**Karuah South Quarry Project – SSD 8795**  
**Further Information required - Environment Protection Authority**

The EPA has reviewed *Environmental Impact Statement for the Karuah South Quarry State Significant Development 17\_8795* prepared by R.W. Corkery & Co. Pty. Limited, dated March 2019 (the EIS) provided with the application, and has determined that it has insufficient information to allow the EPA to properly assess the application.

Figure 4 Operational Scenario 1 – Site establishment and Construction

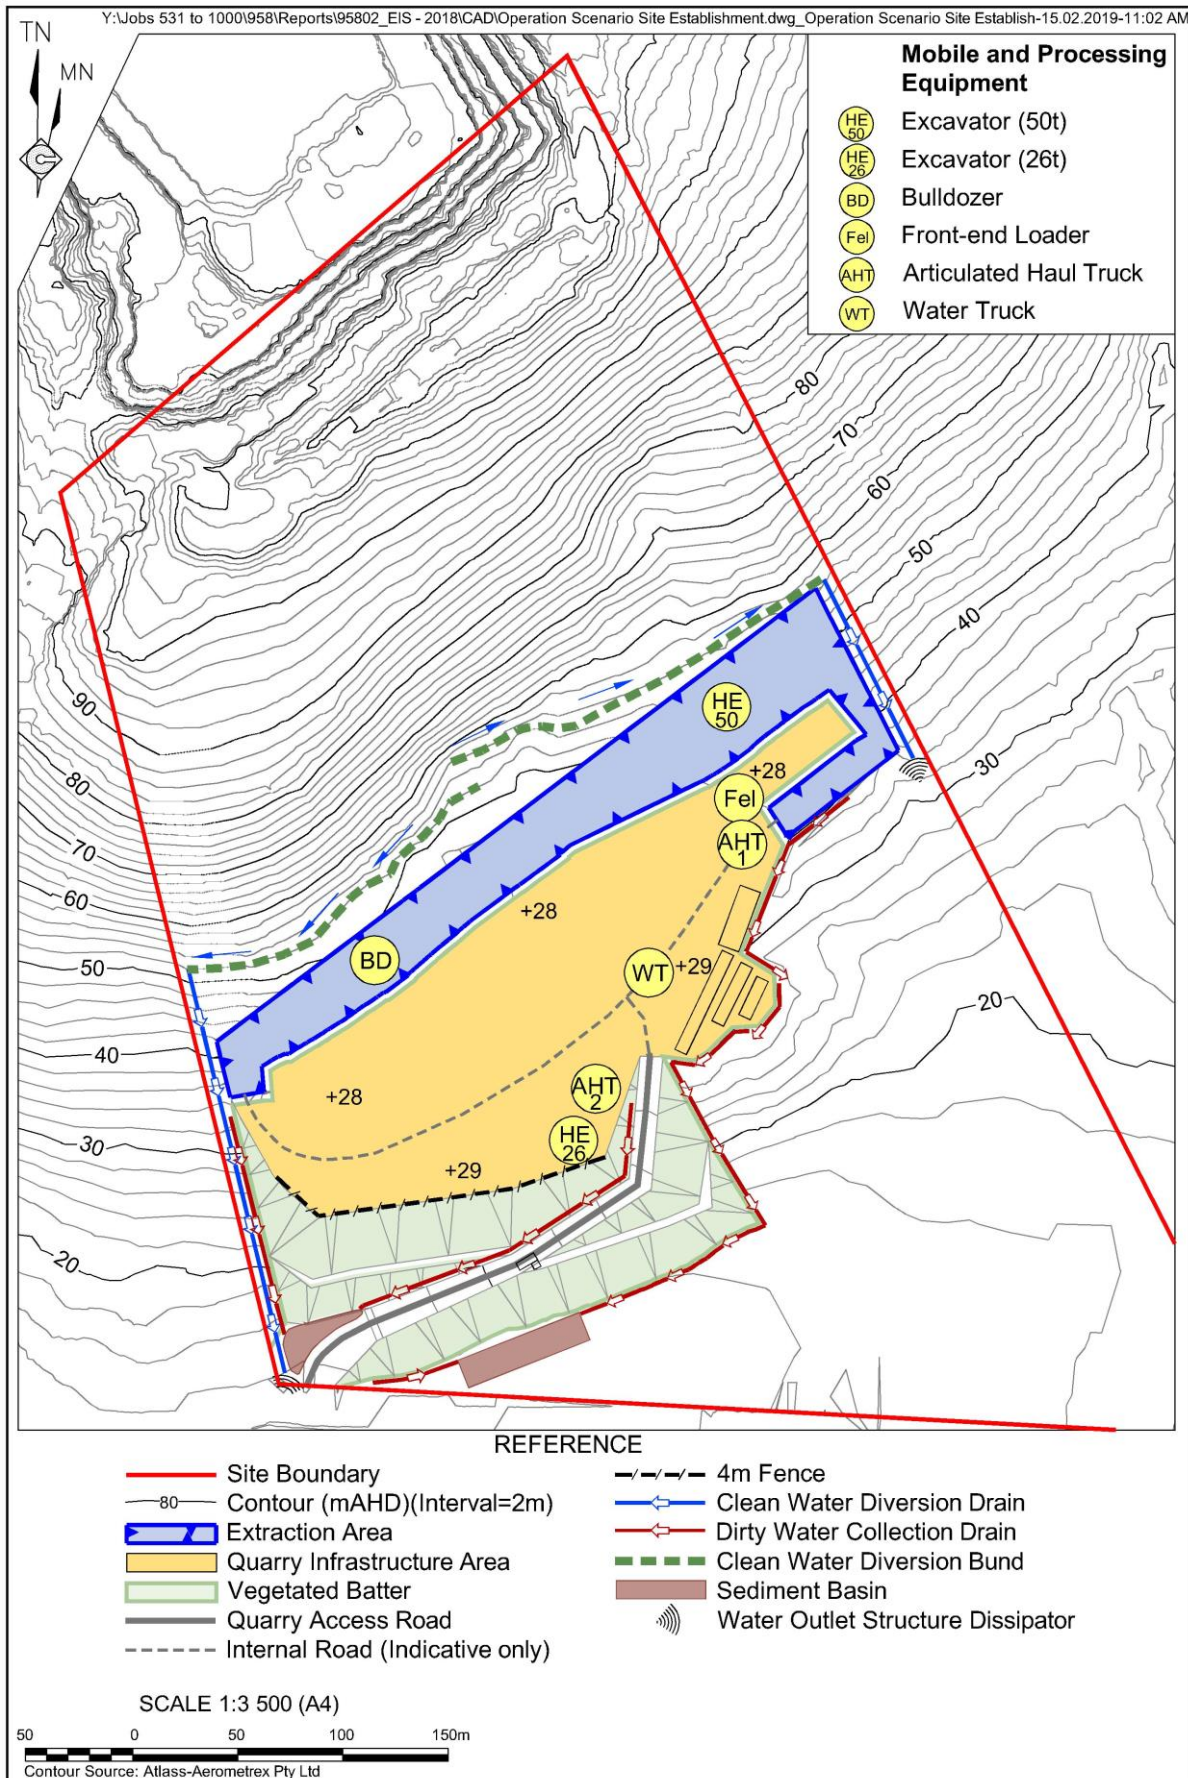
- **Explanation of why acoustic monitoring was not undertaken at R22 given that it is potentially the most impacted residence** - Section 3.2 of the NVIA notes that to quantify the existing acoustic environment at the potentially most impacted receiver, a noise logger was deployed at location R21. The NVIA states that this location was the most representative of the most impacted residence (R22).
- **Explanation of why property "R2" was used in the traffic noise assessment in Section 3.6 of the NVIA.** Property "R22" would normally be used in the traffic noise assessment because it is the closest residence to the Pacific Highway.
- **Confirmation that the 4-metre high acoustic barrier/fence is incorporated into the modelling of Scenario 1 and Scenario 3.** Figures 4 and 6 show that it is present during these scenarios.
